12 November 2013

**Aldwick Farm, Aldwick Rd, Bognor Regis**  
**Condition 3 – Revised matters regarding ref. AW/74/13. and AW/75/13/L**

R.872 **11**
A

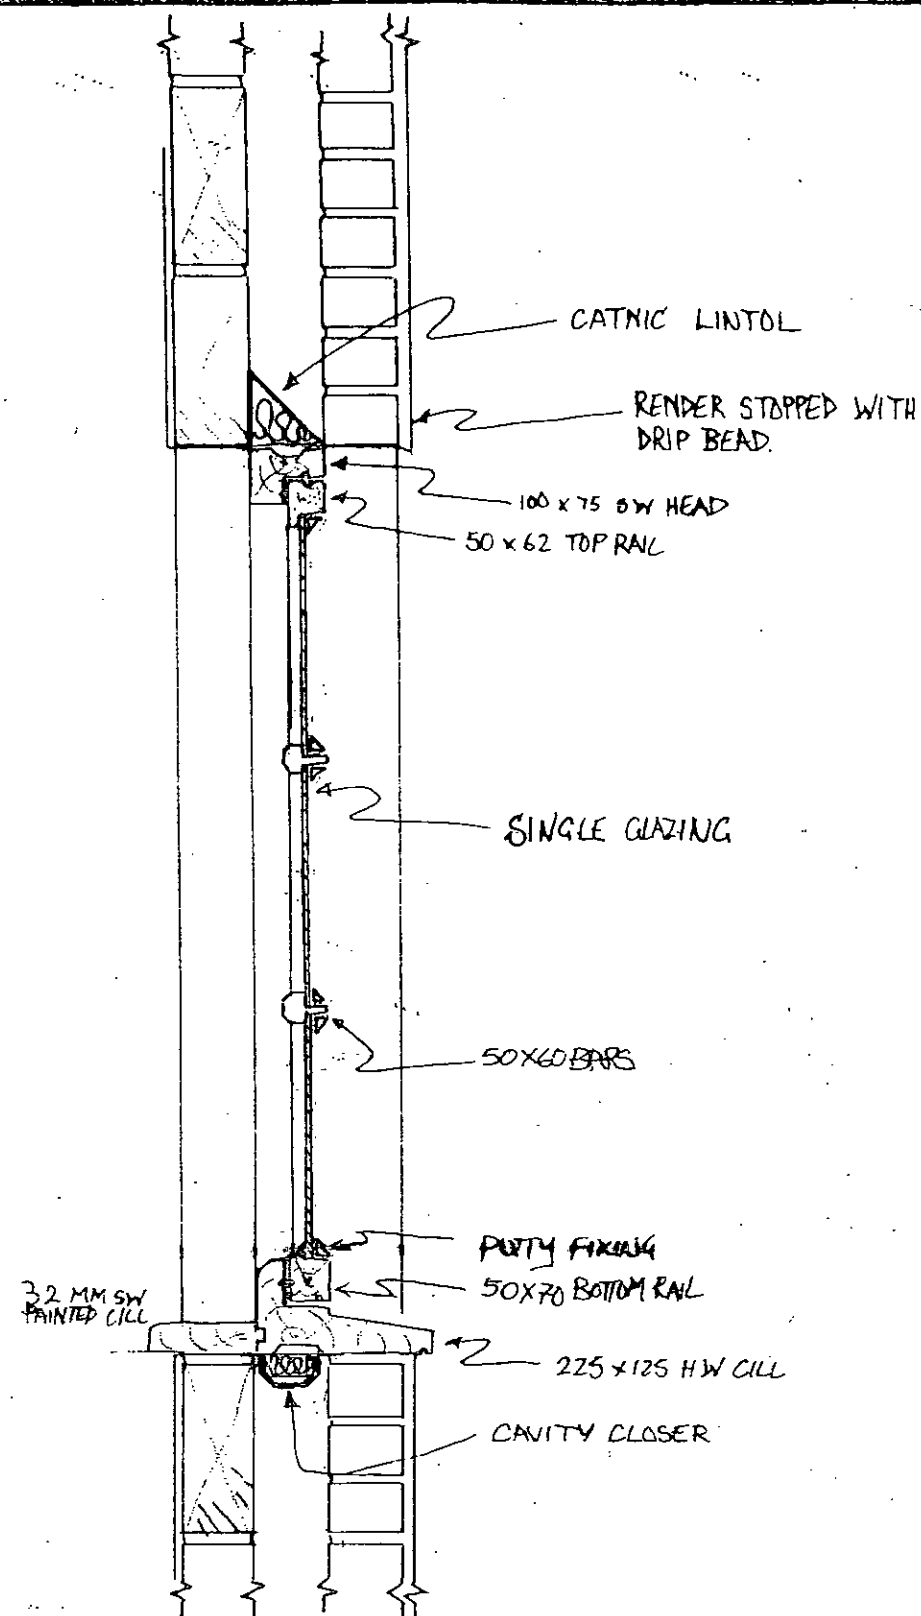
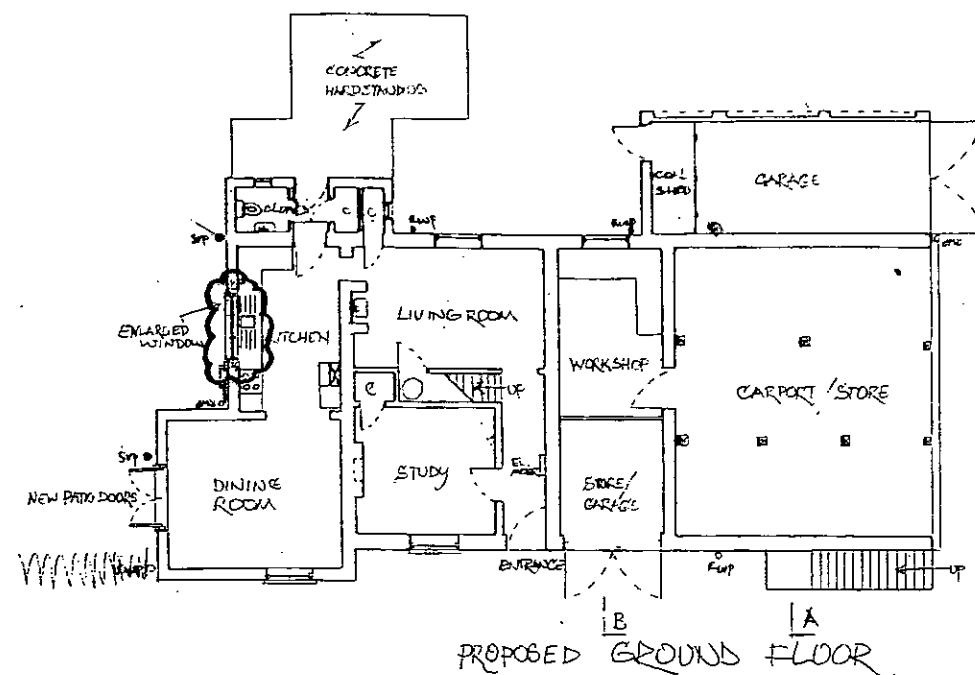
We have amended the drawing R.872 to exclude the double glazing and resubmit the enclosed discharge of condition forms for both the planning and Listed building consents.
